**Our Case Number:** ABP-318573-23

**Re:** A proposed Road Development comprising of the N2 Slane By-Pass and Public Realm Enhancement Scheme  
Within the Townlands of Slane, County Meath

**Re: Reg. Ref. HA17.318573 – N2 Slane Bypass and Public Realm Enhancement Scheme, Slane, Co. Meath**

The National Transport Authority (NTA) has reviewed the subject planning application. Based on the *Greater Dublin Area Transport Strategy 2022-2042* (the 'Transport Strategy'), which is a consideration material to the planning process in the Greater Dublin Area, and the NTA's *Cycle Design Manual*, the NTA submits the following observations and recommendations.

Figure 4.4: N2 Slane Bypass Cycle Strategy

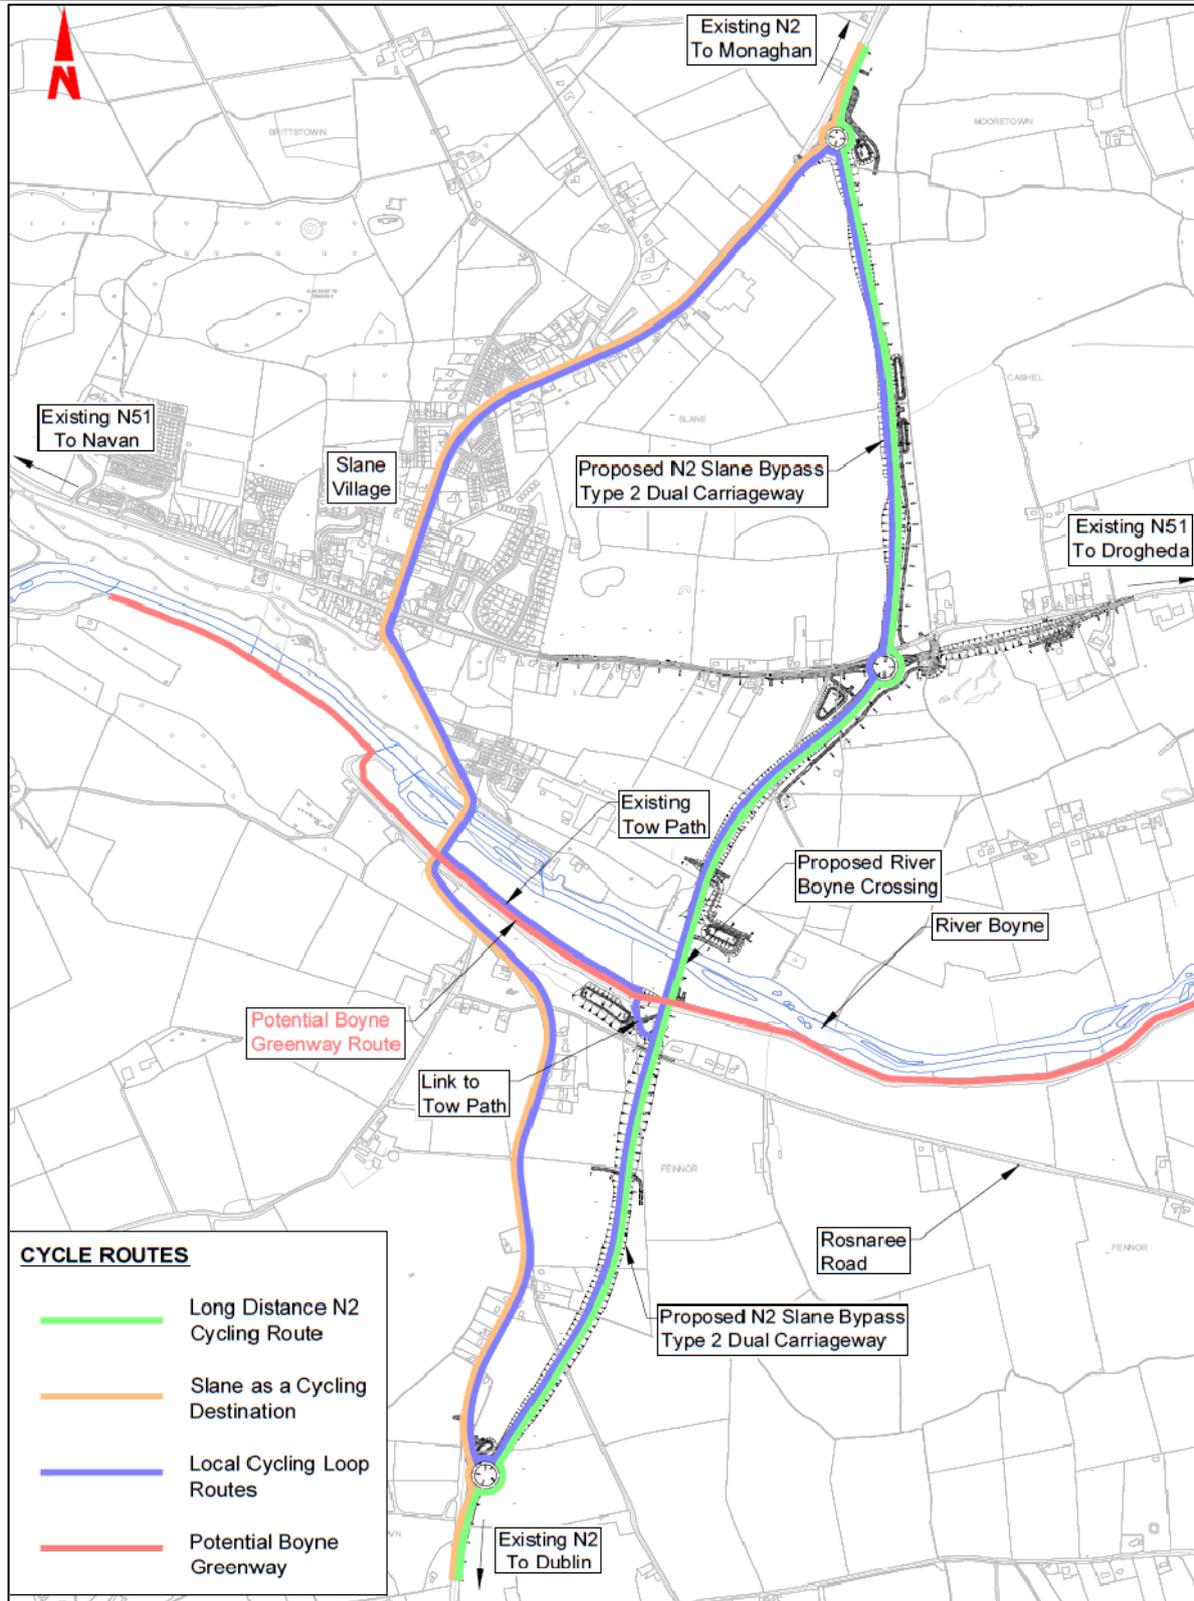
The subject scheme proposes to provide a 2.0m wide shared two-way cycle/pedestrian facility along the western side of the new Bypass. The CDM states that the Desirable minimum width for a two-way cycle track accommodating fewer than 300 cyclists per hour with a gradient greater than 3% is 3.25m, with an Absolute minimum width of 2.25m (CDM Section 2.6; Table 2.2). For shared pedestrian/cycle facilities, the Desirable minimum width is 4.0m, with 3.0m the Absolute minimum width at pinch points (Table 4.16).

Leisure/recreational cycling and walking, while occasionally solitary pursuits, are more often group activities, and facilities for use by such groups should be provided, if feasible. While the design of the proposed bypass in a cutting would present a significant challenge to the achievement of additional width on the full scheme cross-section, the NTA notes that the proposed shared 2.0m wide facility is separated from the vehicular carriageway by a 2.5m wide grass verge on the carriageway side and a 1.0m grass verge on the earthworks side. Subject to alignment with the CDM guidance, which states that the Absolute minimum buffer width between a two-way facility and a 100 km/h carriageway is 1.5m (Table 2.2, part D), provision of increased width on the shared facility for much of the length of the bypass would appear to be achievable through the reallocation of grass verge space on either side.

The NTA recommends that the design of the proposed two-way shared walking and cycling track on the bypass should be reviewed, with a view to providing a wider facility. If it were feasible to increase the width, the NTA would welcome such provision.

Figure 4.23: Public Realm Proposals for Lower Existing N2 South approaching River Boyne

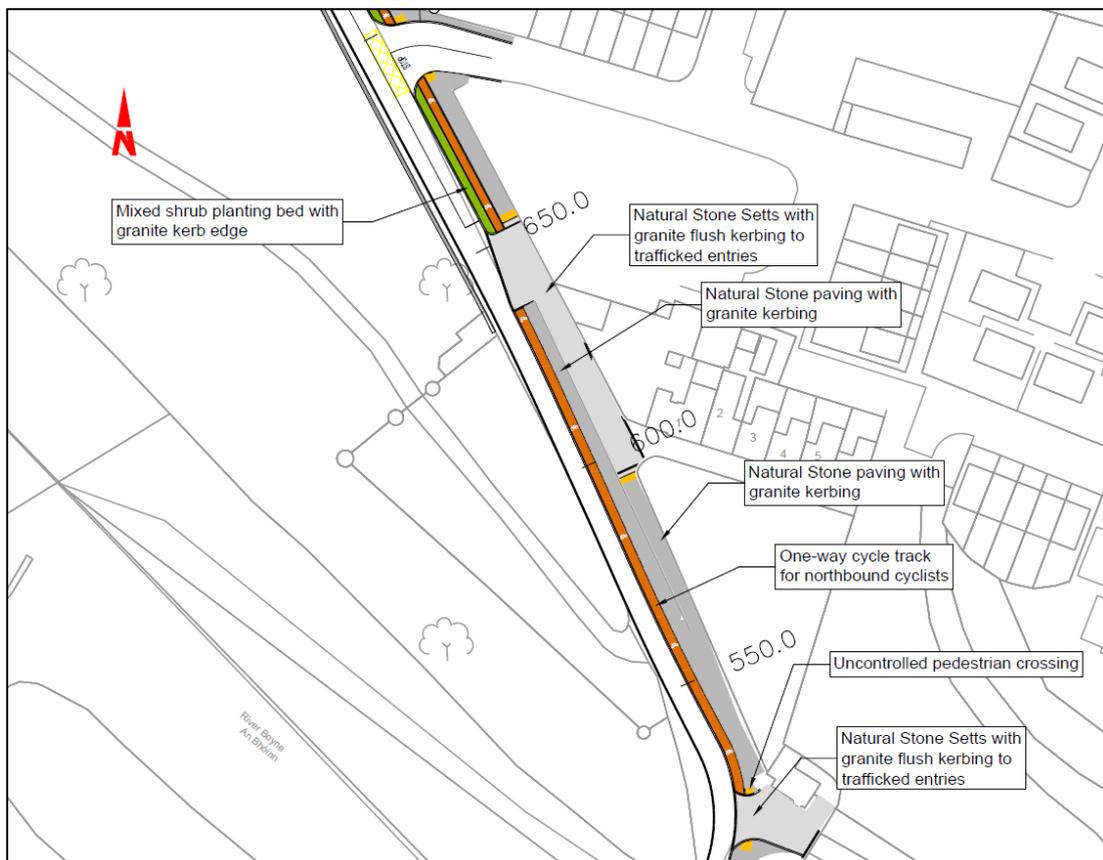
The subject scheme proposes to provide a northbound cycle track on the east side of the old (i.e. current) N2 between the River Boyne and the crossroads in the village centre. Given the significant incline on this road, such provision is welcome. However, in light of the uphill track being on the east side of the road, i.e. where a with-flow (downhill) track would usually be expected, the design of the crossovers at the side roads to the east of the N2 require careful consideration. In this regard, the NTA is supportive of the proposal to provide traffic signals at the Millhouse and Boyne View junctions to control traffic entering the one-way portion of the route from these side roads. However, such signals do not appear to control movements into the side roads from the N2. The NTA therefore recommends that clear warning signage should be provided, addressing both turning motorists and ascending cyclists, in tandem with tight corner radii at these junctions to slow turning vehicles.

Due to the narrow deck of the Slane Bridge, a cross section comprising a 4.0m carriageway and a 2.0m footpath is proposed. The current traffic regime, whereby movements across the bridge are managed by traffic signals at each end to implement shuttle-working, is proposed to be retained, with the exception of the signalised pedestrian crossing to the north of Mill Lodge (entrance to Millhouse). While the NTA is not opposed to such a solution, considerable care would be required in the design of the traffic signal stages and offsets, in order to ensure that sufficient intergreen time is provided for cyclists to clear the deck of the bridge. This is particularly important given the proposed location of the northern signals, which do not provide a line of sight to the bridge deck or to cyclists crossing from the bridge deck to the start of the uphill cycle track at Mill Lodge. As noted above, the subject scheme proposes to control traffic entering the one-way portion of the road from the Millhouse by means of traffic signals. The NTA recommends that consideration should also be given to the use of traffic signals to control southbound mainline vehicular traffic on the old N2 at the Millhouse junction in the interests of cyclists' safety.

The NTA recommends that the design of the junctions along the proposed uphill cycle track north of the river should include clear warning signage addressing both turning motorists and ascending cyclists, and tight corner radii to slow turning vehicles.

The NTA also recommends that the design of the traffic signal cycle at Slane Bridge should account for the speed of cyclists across the bridge deck and the compromised line of sight from the northern signals towards the bridge deck, and that consideration should be given to the use of traffic signals to control southbound mainline vehicular traffic on the old N2 at the Millhouse junction.
